Please ask for: Sian Eggington
Email: sian.eggington@terraquest.co.uk
Telephone: 0121 2341390
Our Ref: FP/197/20/HH
Your Ref:
Date: 19th October 2020

Application for Planning Permission for Works or Extension to a Dwelling

Development: Two storey extension to front elevation, extension over rear terrace, single storey side and rear extension and loft conversion with rear dormer window and two modest front facing dormer windows. Rear facing roof terrace. Alterations to the vehicular access

Location: 15 Blakes Road Felpham PO22 7EE

SITE PLAN

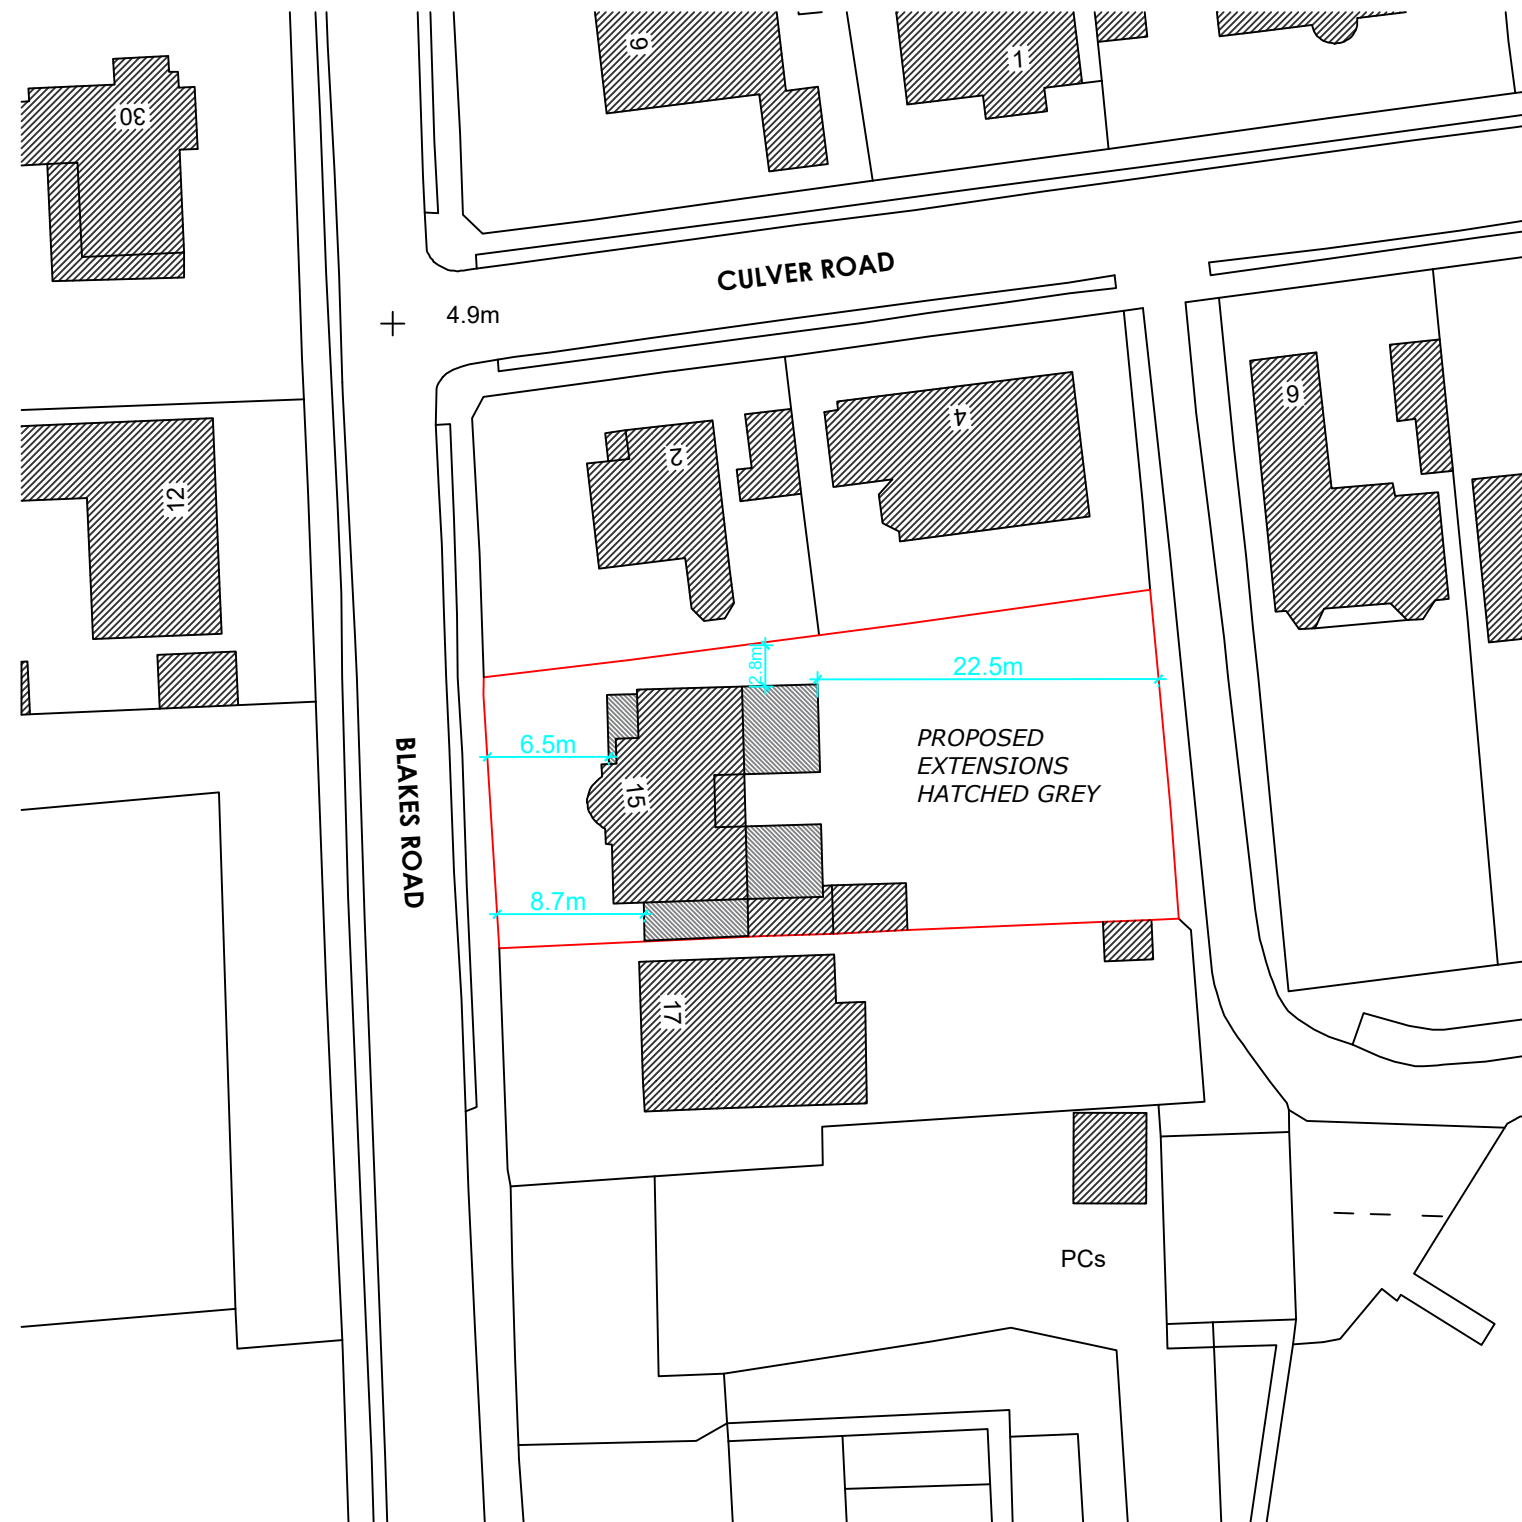
Dimensions: You are required to include all dimensions from all extensions to all site boundaries.
Flood Risk Assessment

ACCESS PLAN (SHOWING SPLAY)

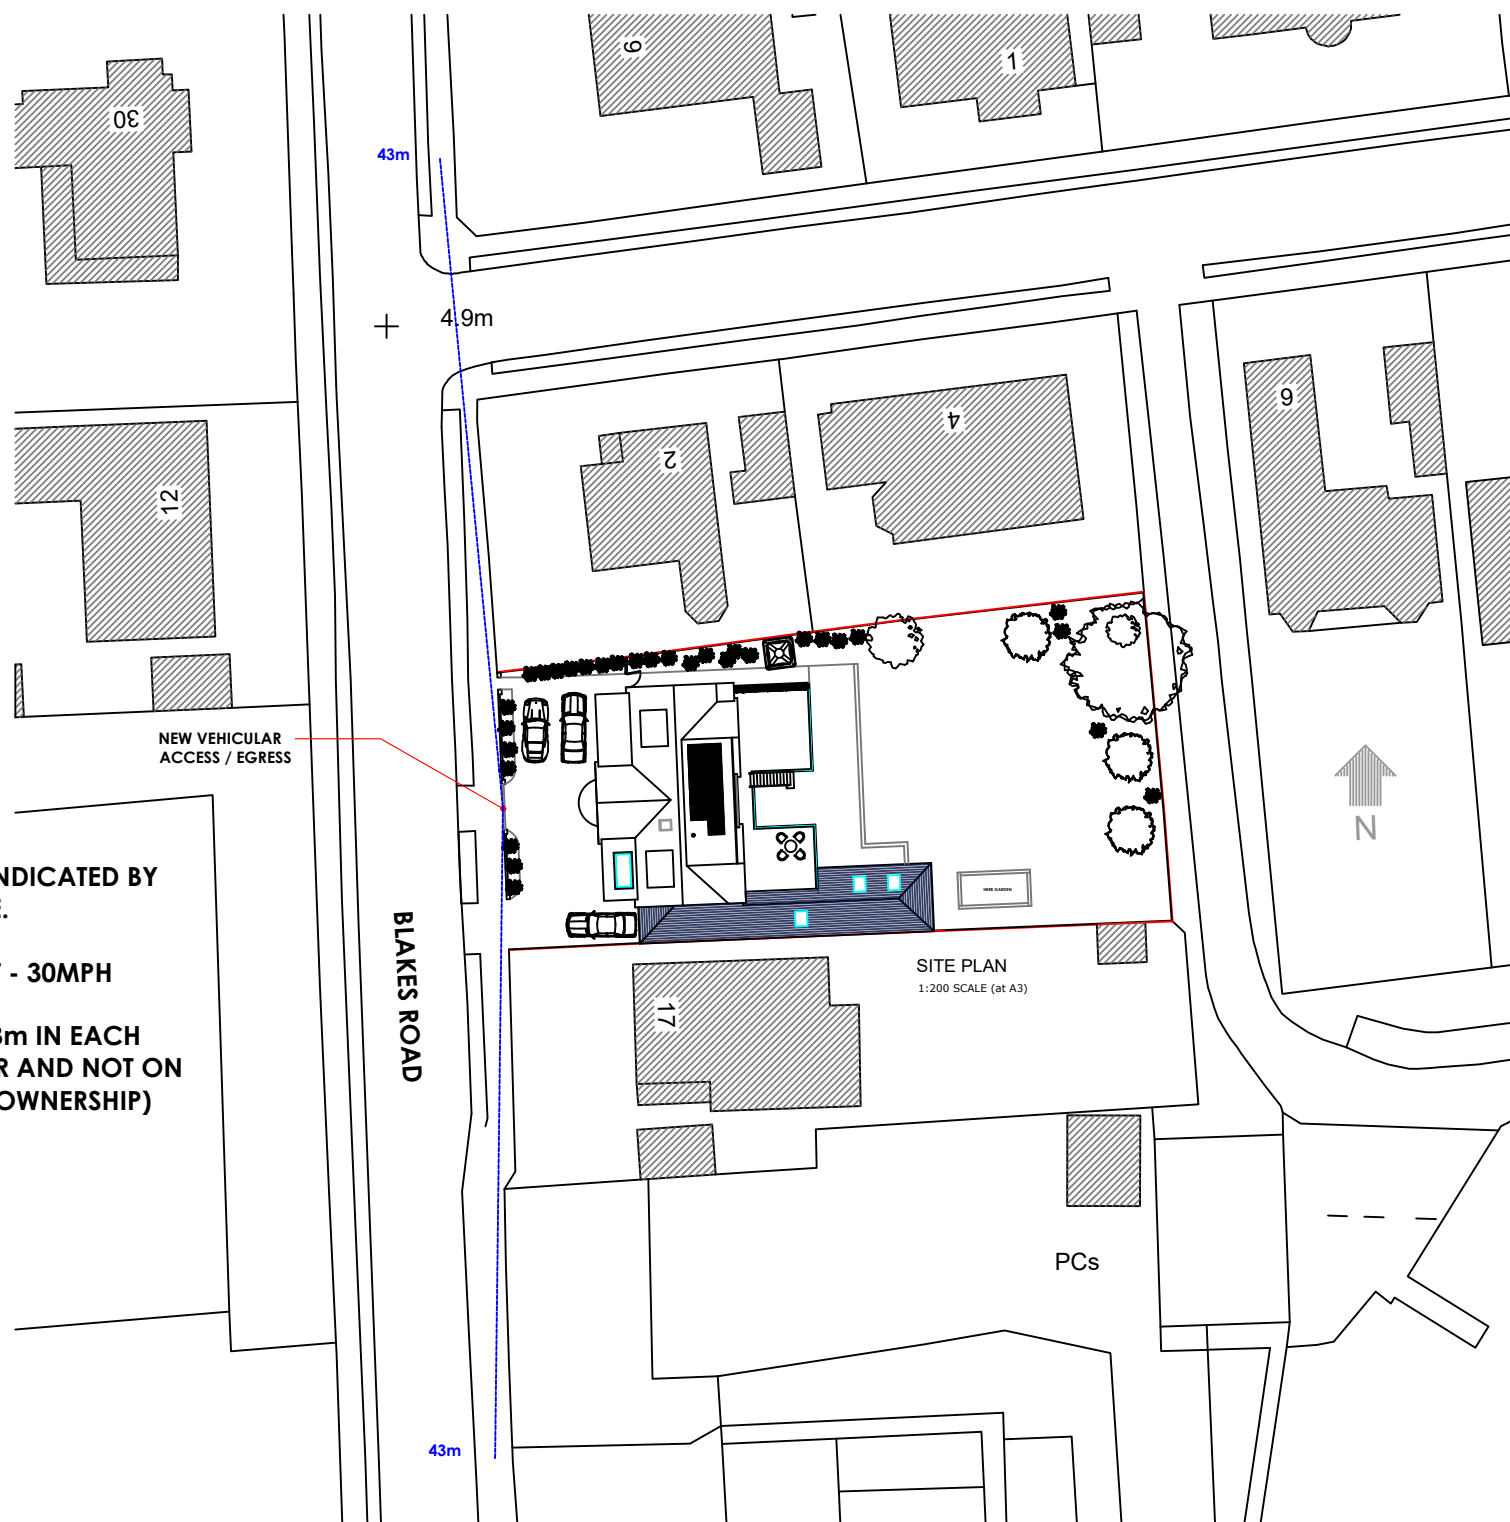
West Sussex County Council require that a visibility splay is provided. A splay is formed for a 30 mph speed limit road by measuring from a point 2.4m back from the kerb edge in the centre of the proposed access. A line should then be drawn from either side of this point for 43 m in each direction to the nearside edge of the carriage way. The splays must intersect and only within the control of the applicant, or within the publicly maintained highway.
